Application for a non-material amendment following a grant of planning permission.

Number	
Suffix	
Property name	Bedfont Cross
Address line 1	Stanwell Road
Address line 2	
Address line 3	
Town/city	Feltham
Postcode	TW14 8NX
Description of site location must be completed if postcode is not known:	
Easting (x)	508168
Northing (y)	173874
Description

Change of use of offices (Use Class B1a) to 44 residential units (Use Class C3) (Application for Prior Approval under Schedule 2, Part 3, Class O of the Town and Country Planning (General Permitted Development) (England) Order 2015)

Reference number:	50395/APP/2019/194
Date of decision	09/08/2019

DESCRIPTION
PROPOSED GROUND FLOOR PLAN

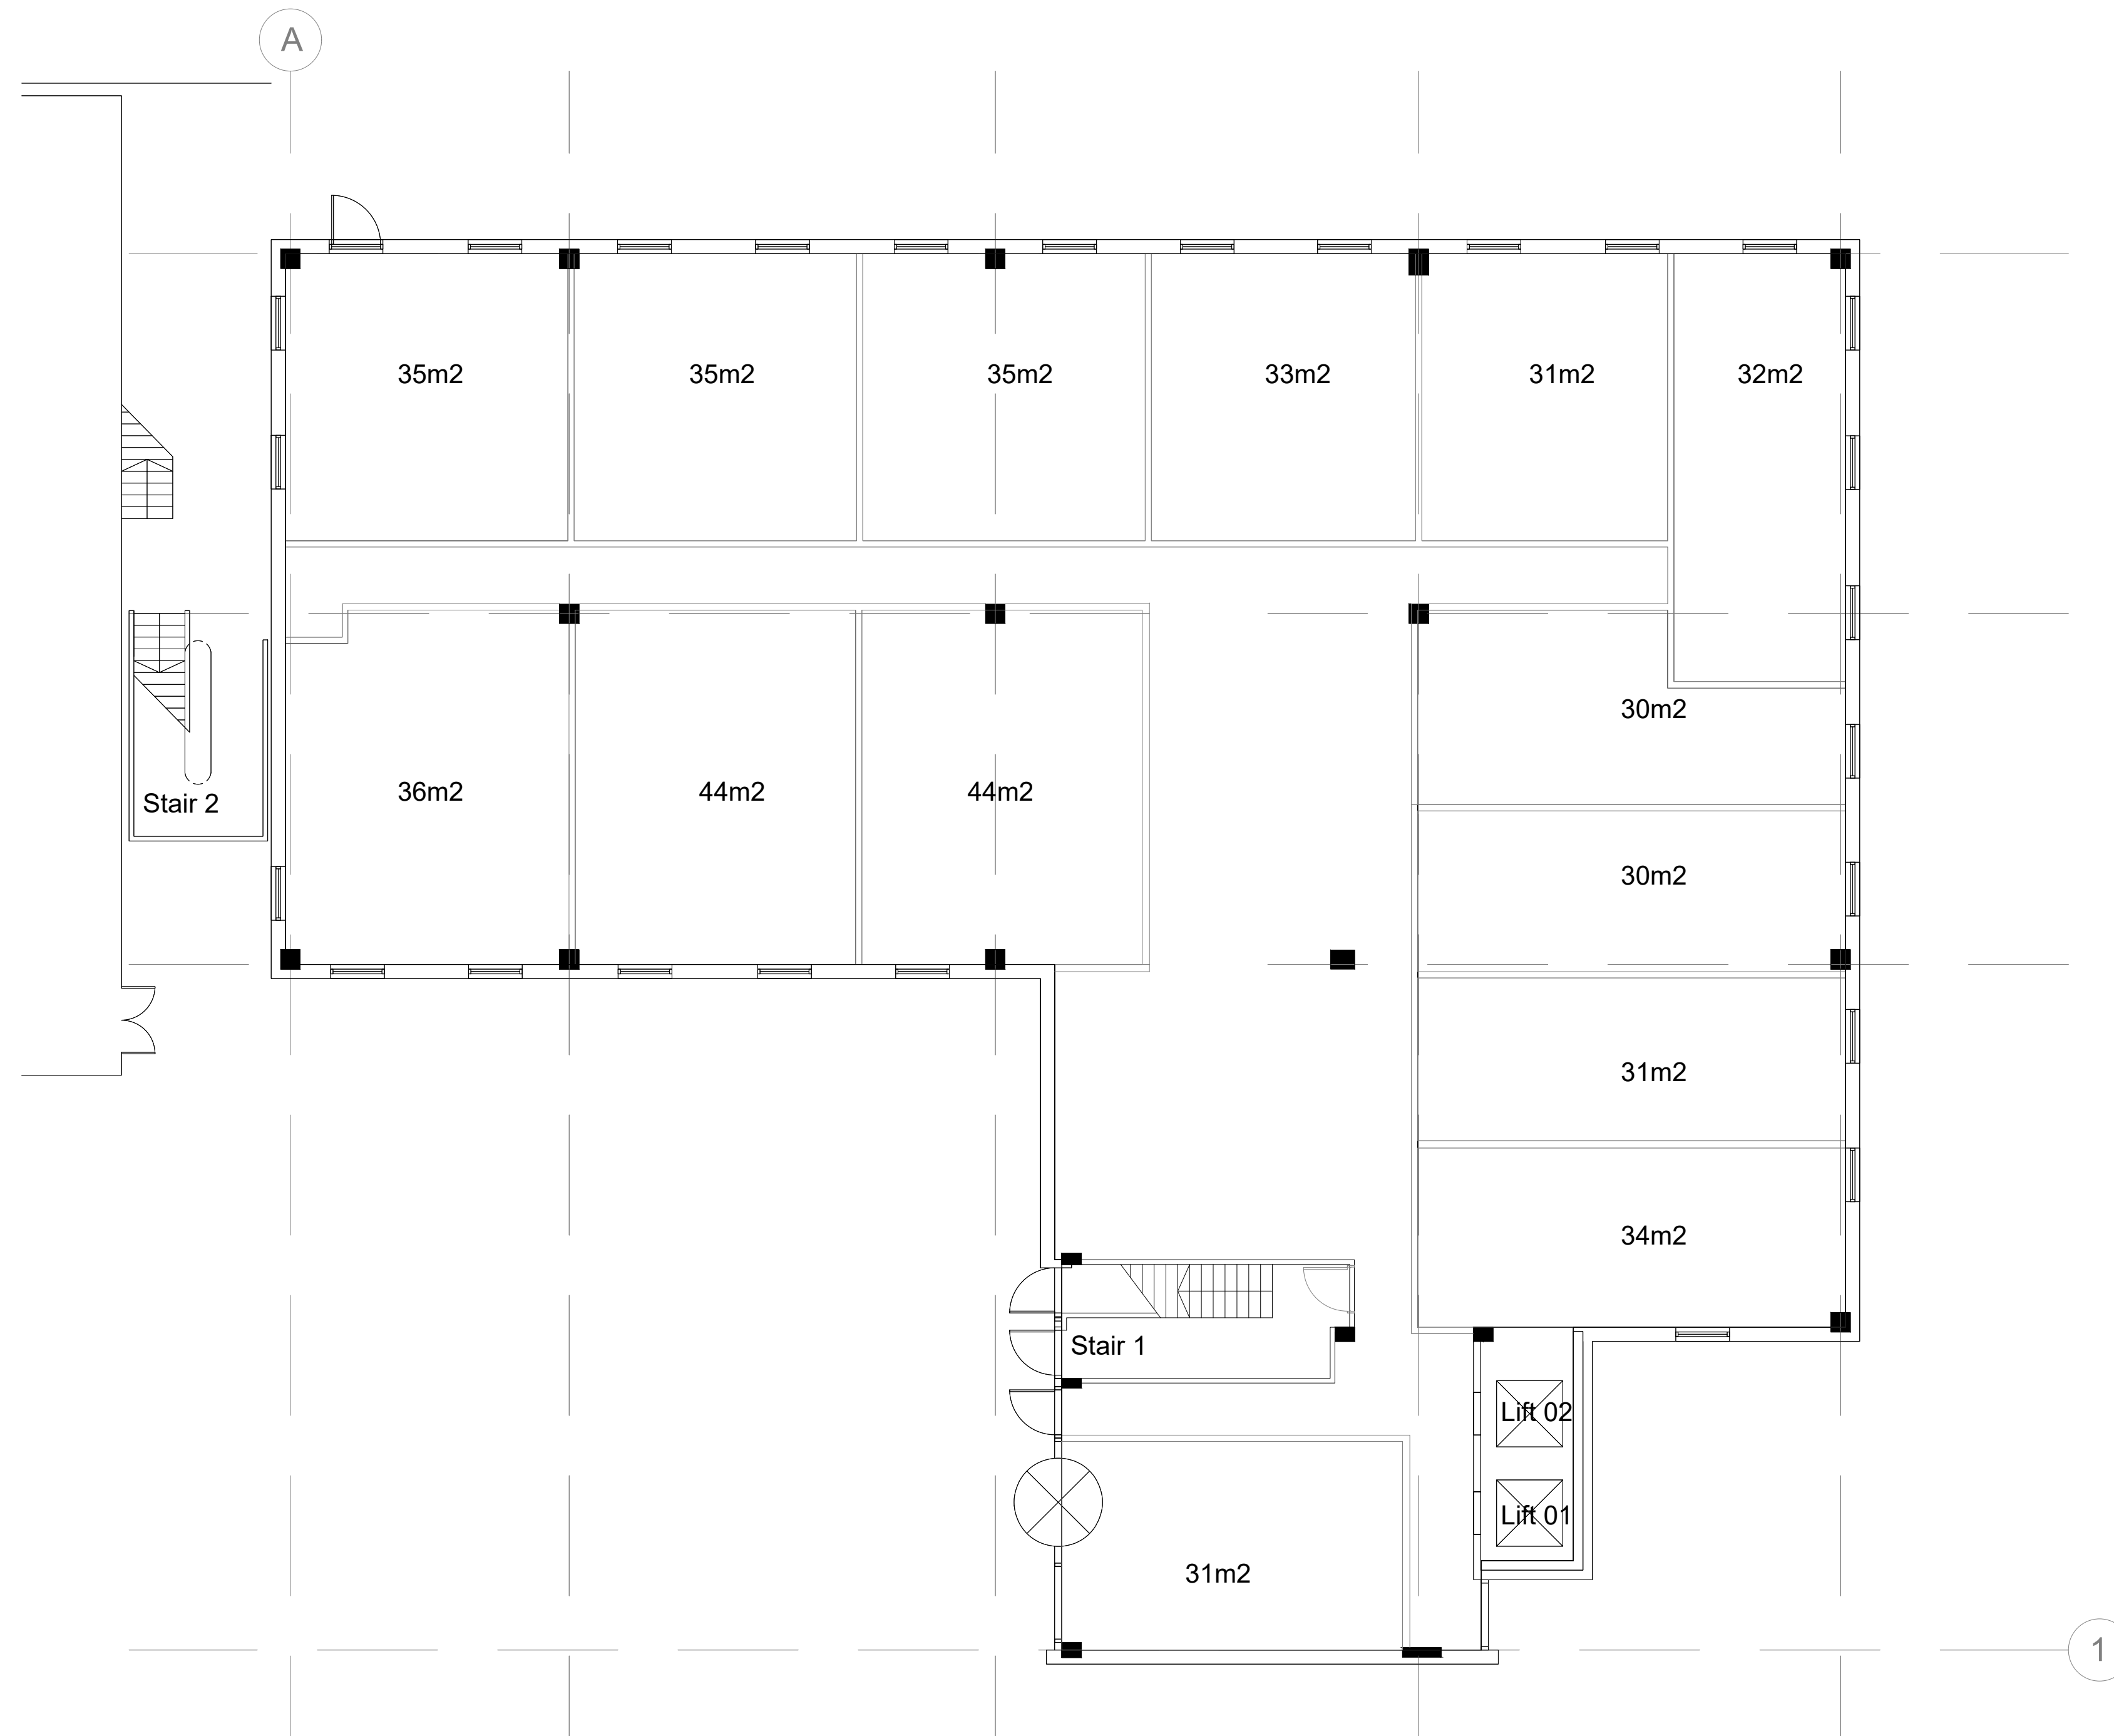
Internal reconfiguration of units to maintain existing stairwell.

Relocation of stairwell.

Proposed Ground Floor Plan (210001 P01)
Proposed First Floor Plan (Dwg No. 210001 P02)
Proposed Second Floor Plan (Dwg No. 210001 P03)
